One Earth Solar Farm

Applicant Response to ExA Written Questions 3

Document Ref: EN010159/APP/9.43

December 2025

Figure 2.1 Site Access Location Plan

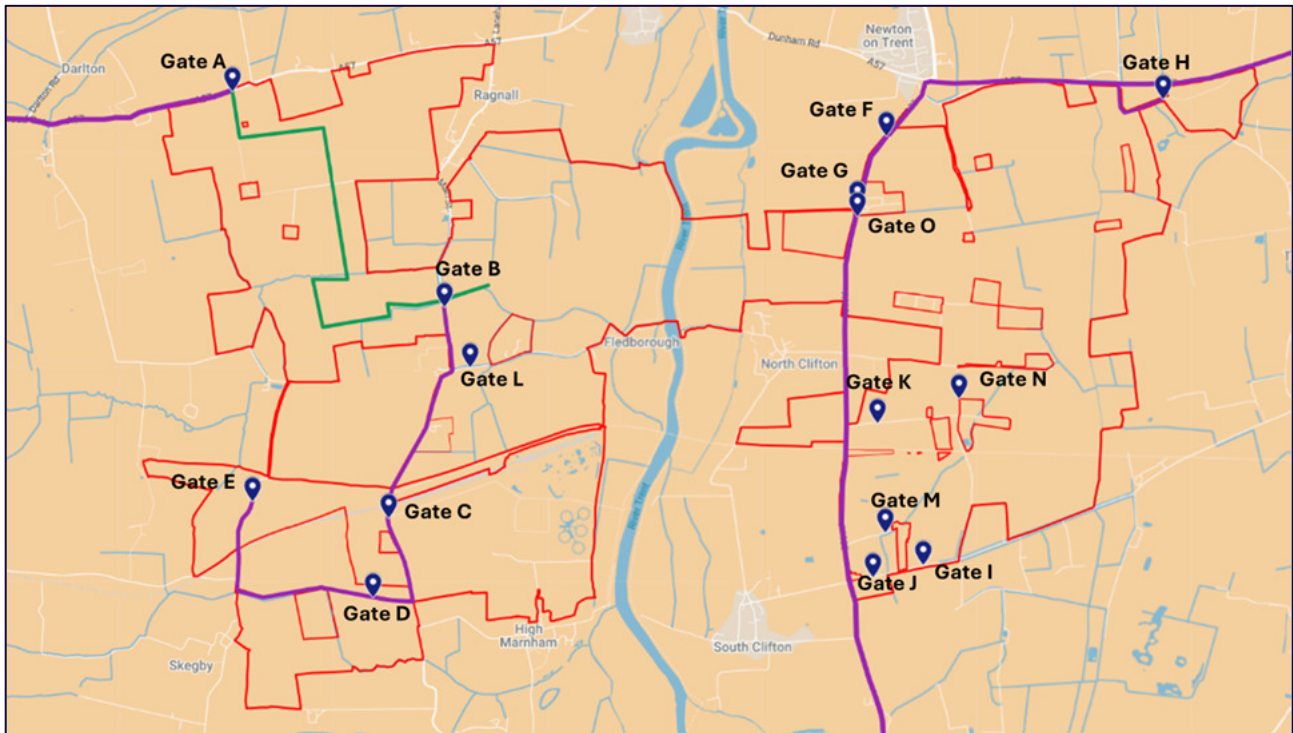
Transportation and traffic		
Q18.0.1	<p>Visibility splays</p> <ol style="list-style-type: none"> 1) Can the Applicant please provide evidence to substantiate the claim made at ISH3 and subsequently stated at D5 [REP5-071], that land outside the control of the Applicant (i.e. outside of the RLB and not on public highway) will not be required to provide visibility splays, as shown on drawings. 	The Applicant wishes to clarify this applies to a single location at Access 9 as depicted in the Transport Assessment [REP5-030]. In this location, the maximum visibility splay passes outside of the Order limits. This splay has been identified based on the outline design parameters and posted speed limit (rather than recorded speed limit). The design will be refined at detailed design and include a further review of measured road speeds.

App Ref	Summary	Applicant Response
	<p>2) Whilst noting the Applicant's reference to Requirements 5 and 15, can the Applicant please explain what happens in the situation that speed surveys show that full visibility splays are required for access points, being greater than the land within the RLB?</p> <p>Can the Applicant please explain what actions are necessary to give the SoS comfort that the access points as described with the dDCO are deliverable and appropriate visibility splays can be achieved to ensure the safe operation of the proposed access points?</p>	<p>During the construction phase, the Applicant would seek to implement a temporary speed limit reduction in the vicinity of the access to provide the appropriate stopping sight distances based upon speed survey data. Article 16 of the draft DCO provides the power for the undertaker to make traffic regulation measures, including making temporary provision as to the speed at which vehicles may proceed along any road.</p> <p>If the measured road speeds indicate that a visibility splay is required outside of the Order limits in this area, the undertaker would therefore rely on Article 16 to temporarily limit the road speeds to ensure the access point can be utilised safely. Additional measures including the use of temporary traffic signals and banksman monitoring may also be provided.</p>

*Figure C.2: Impacts from Unplanned Emissions at Eastern BESS Compound*

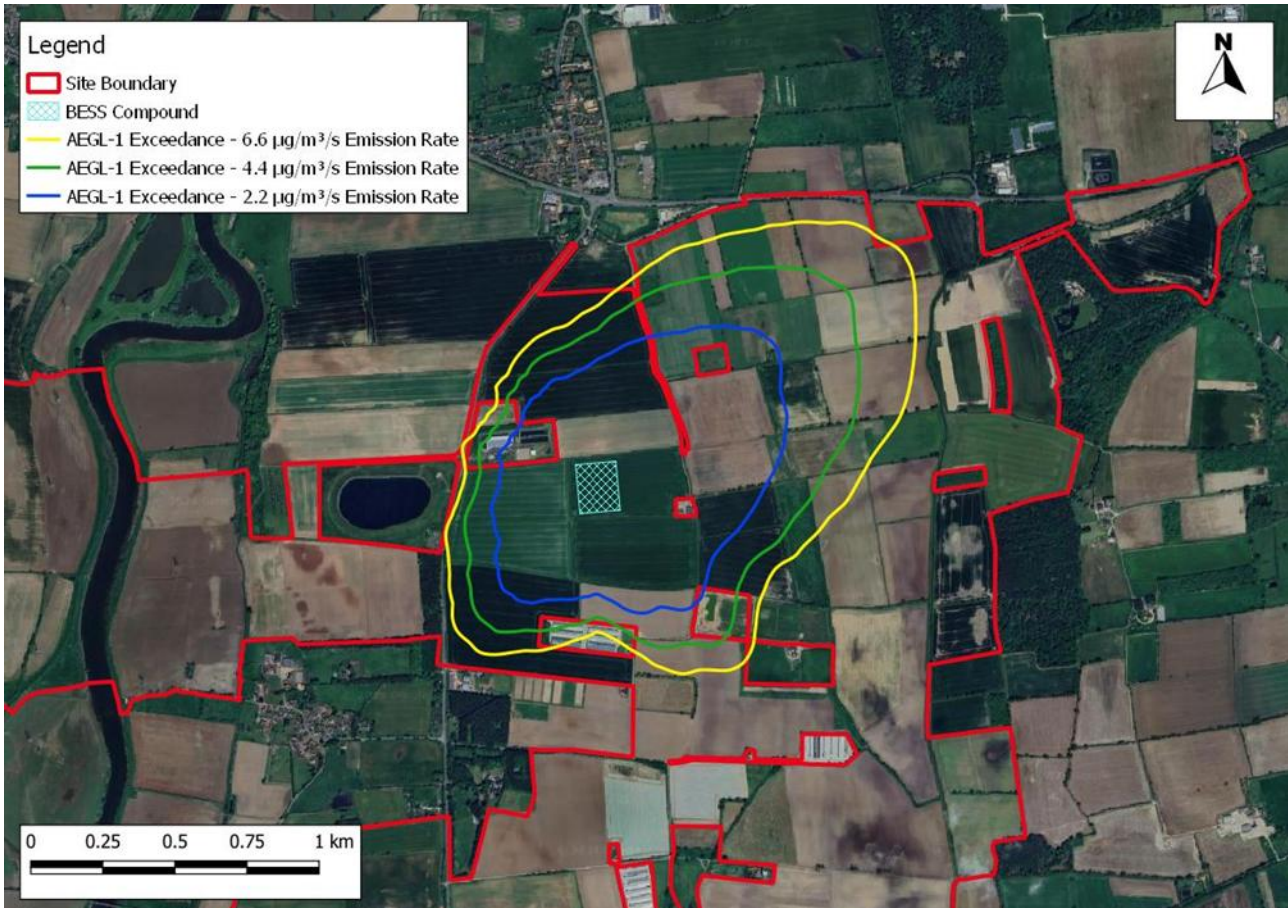
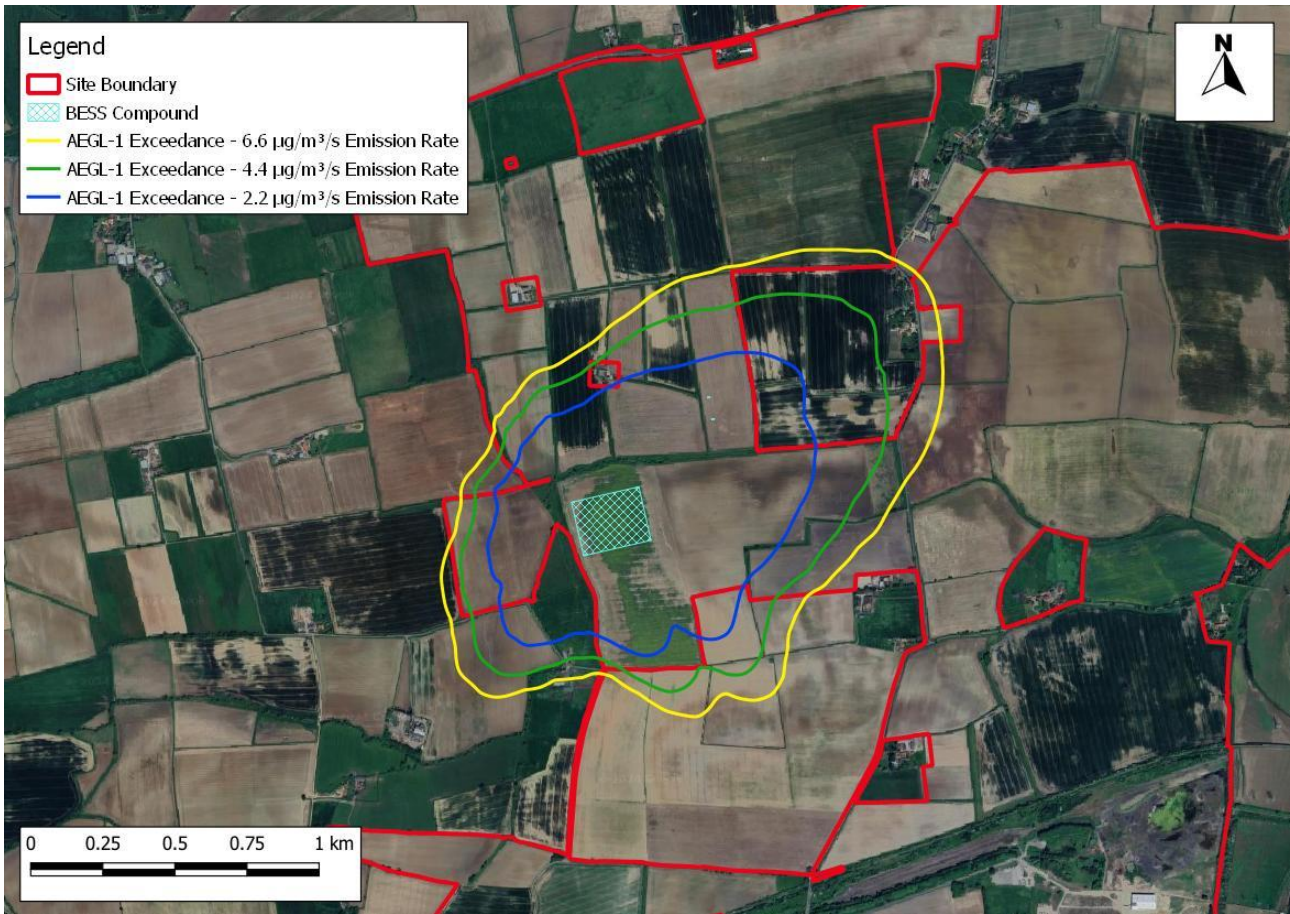
Air quality and emissions		
Q6.0.1	<p>BESS unplanned emissions</p> <p>At ISH3, an IP stated that in the assessment of unplanned emissions contained within the oBSMP [APP-183], it states that no sensitive receptors have been identified.</p> <p>Can the Applicant please confirm how this conclusion has been reached, including why poultry sheds and a reservoir in the locations affected have not been identified?</p>	<p>The assessment in the oBSMP [REP5-044] focussed on unplanned emissions of hydrogen fluoride (HF) to air in the event of a thermal runaway scenario. HF is not considered a long term ecological pollutant and does not carry a hazard classification for harm to aquatic life. The only established exposure guidelines relate to human health.</p> <p>On that basis, the assessment identified residential receptors as the sensitive receptors for consideration. Poultry sheds and the reservoir were not included because the risk assessment methodology is based on acute human health exposure thresholds rather than ecological or agricultural sensitivity;</p>

App Ref	Summary	Applicant Response
		There is no evidence that HF is harmful to aquatic life. The Unplanned Emissions assessment is based on the methodology used on multiple other solar farm DCOs and accepted as the industry standard approach.
Biodiversity, ecology and natural environment (including Habitats Regulations Assessment (HRA))		
Q7.0.1	<p>Adequacy of fish assessment</p> <ol style="list-style-type: none"> 1) In light of the outstanding matters in the latest iteration of the draft SoCG can both parties advise on their position and how you anticipate the differences between you can be resolved. 2) In the event the matters remain in dispute can the EA advise how either a requirement or management plan might be adjusted to provide appropriate mitigation to ensure the relevant species are appropriately protected. 	<p>The Applicant has revised the Environmental Statement, Chapter 6 Biodiversity [REP4-014] at Deadline 6 to include fish species explicitly in the list of species considered. This update will ensure completeness and clarity and does not alter the outcome of the assessment because the mitigation embedded into the design and to be implemented through the Construction Environmental Management Plan account for impacts on all fish.</p> <p>It is the Applicant's understanding that the issue relates to completeness, as opposed to disagreement on the outcome of assessment.</p>
